**DPIE REQUEST FOR ADVICE – HUNTLEE STAGE 2 – SSD-70748466**

I refer to your request via the NSW Major Projects Planning Portal for advice from Singleton Council on the Environmental Impact Statement and accompanying information for Huntlee Stage 2 - SSD-70748466. Council notes that the due date for submissions was the 19 August 2024.

HUNTLEE STAGE 2 DA VILLAGE 2
 CENTRAL & SOUTH DETAILED
 SUBDIVISION PLAN (8)

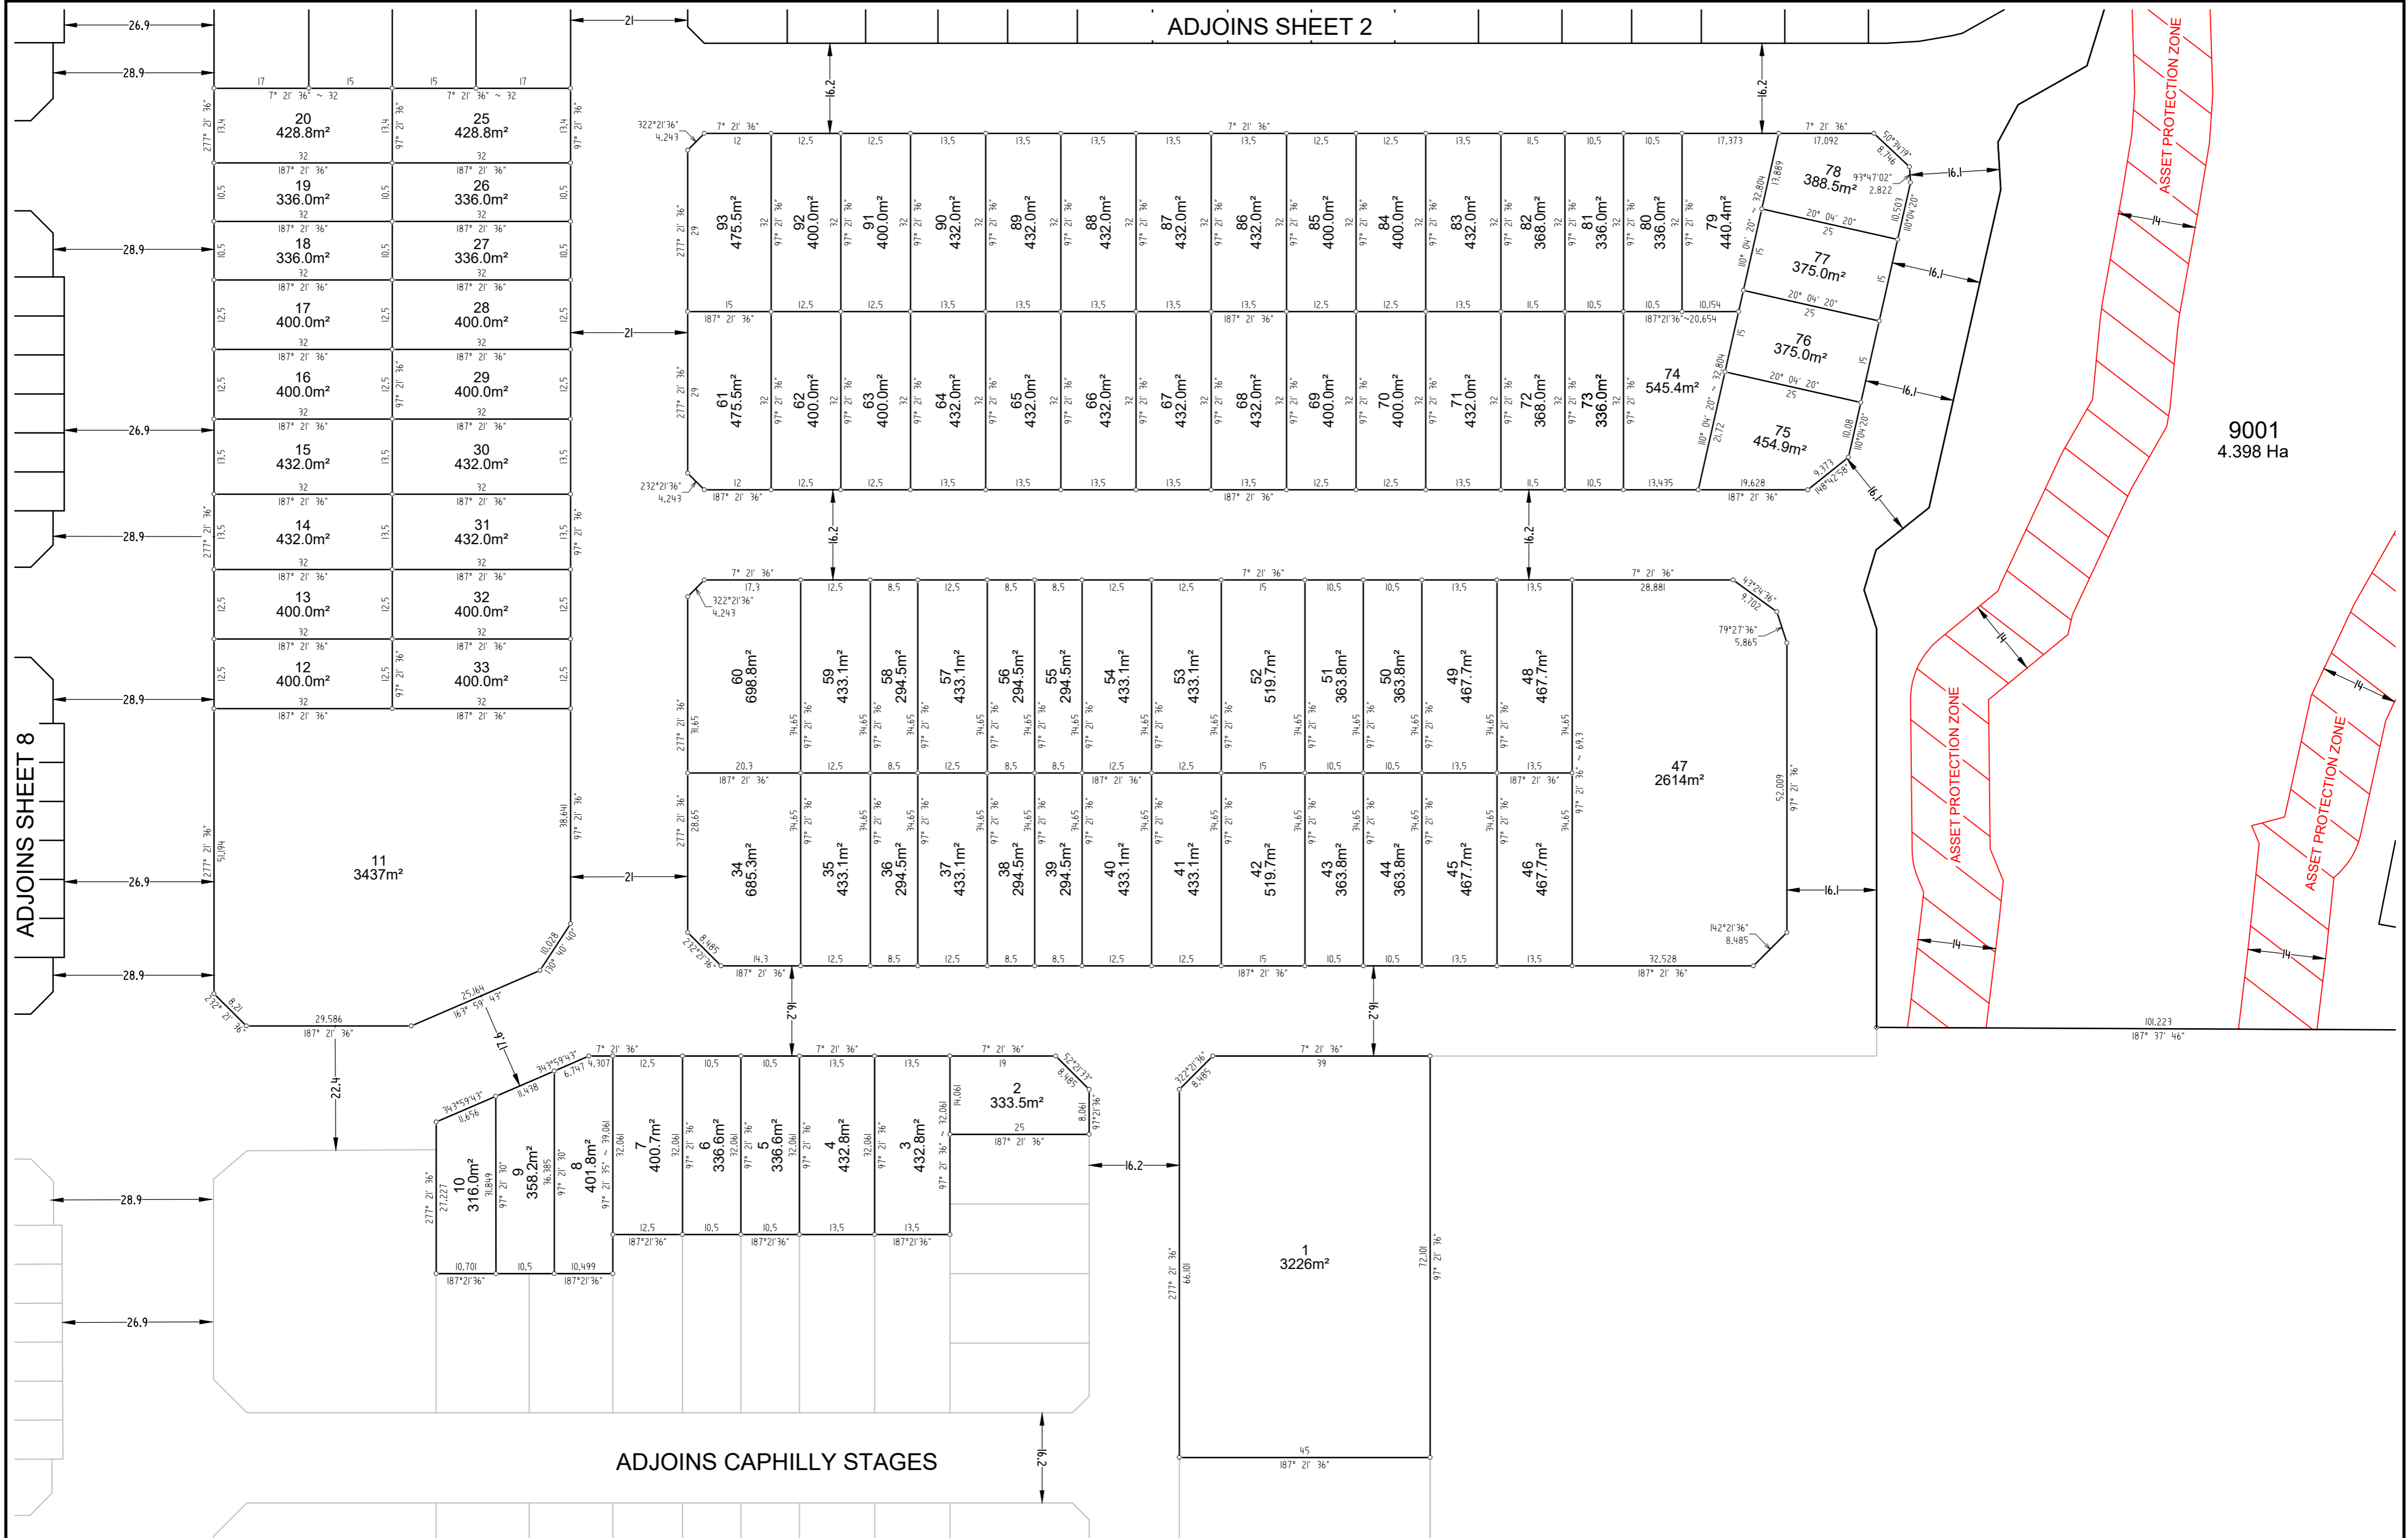
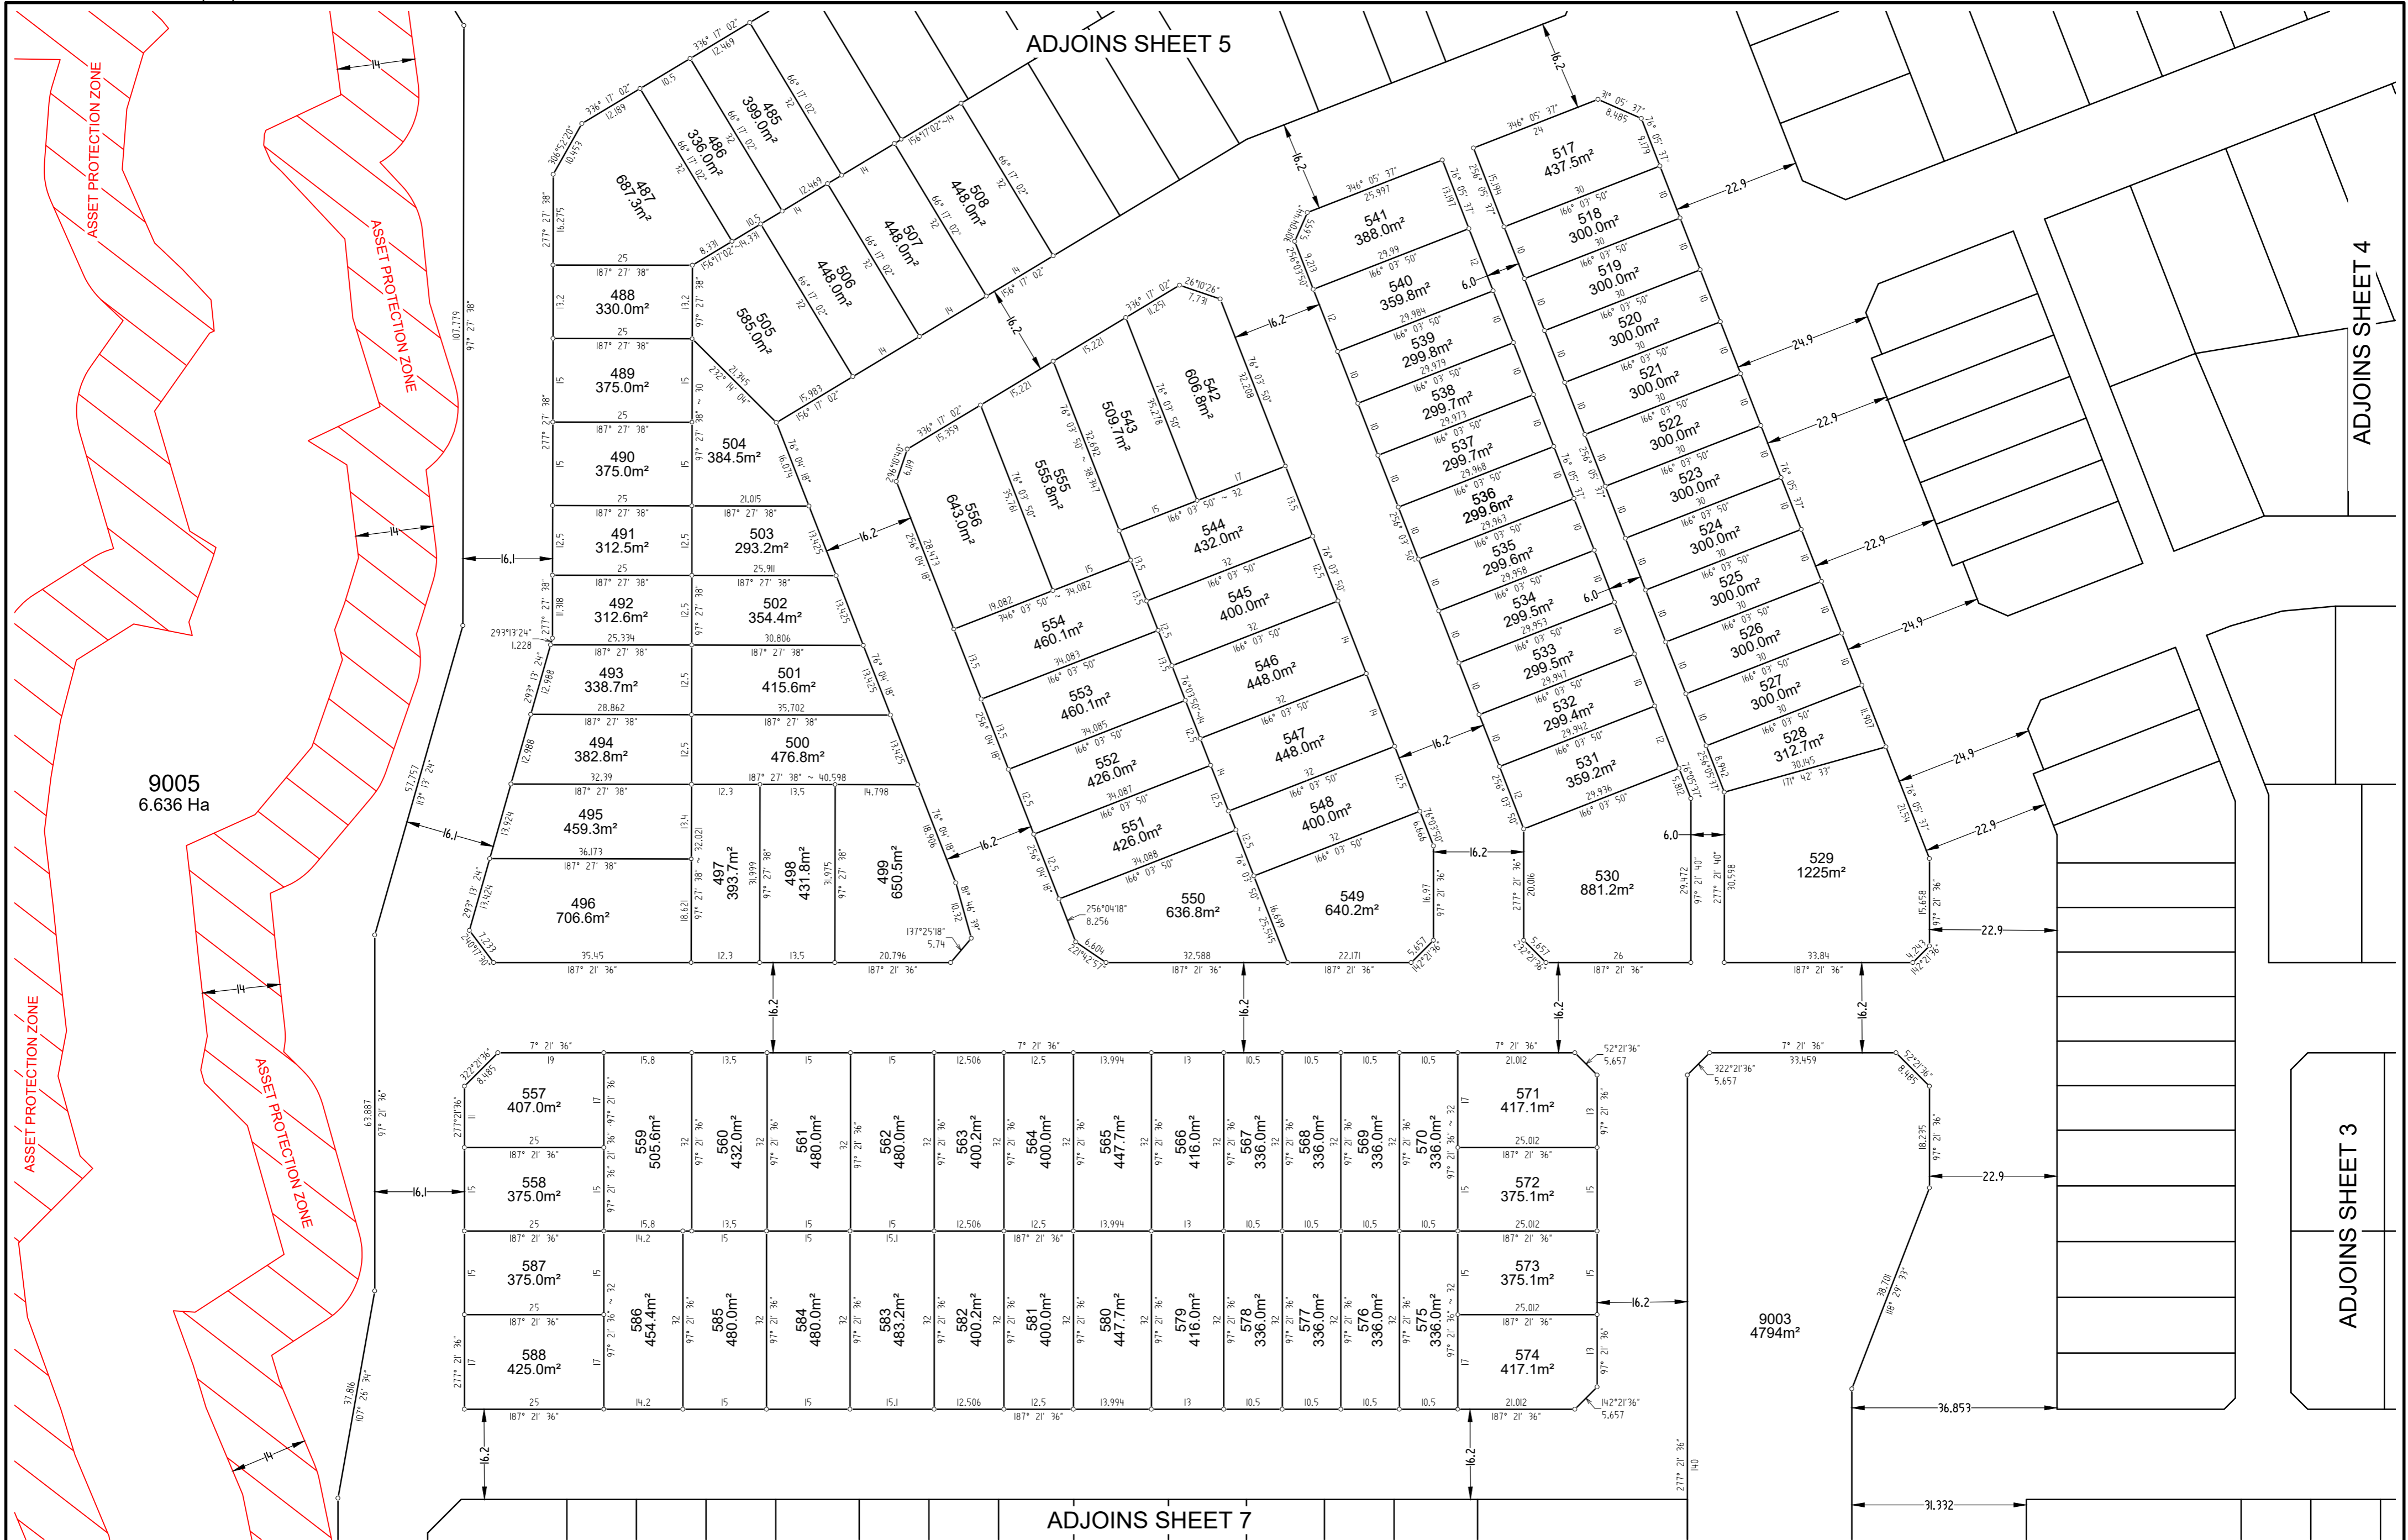
The detailed subdivision plan for Village 2 shows that the Developer is indicating that the proposal will meet targets regarding supplying a range of lot sizes to enable diverse housing. Further detail on the controls that will apply to prevent these larger lots from being further subdivided through modifications. For example, there are approximately 20 medium density lots in Village 2 Centre and South, and it is unclear what controls are in place to stop these being further subdivided into the smaller Cottage lots by either the Developer or future owners of the lot, noting this has happened in Stage 1.
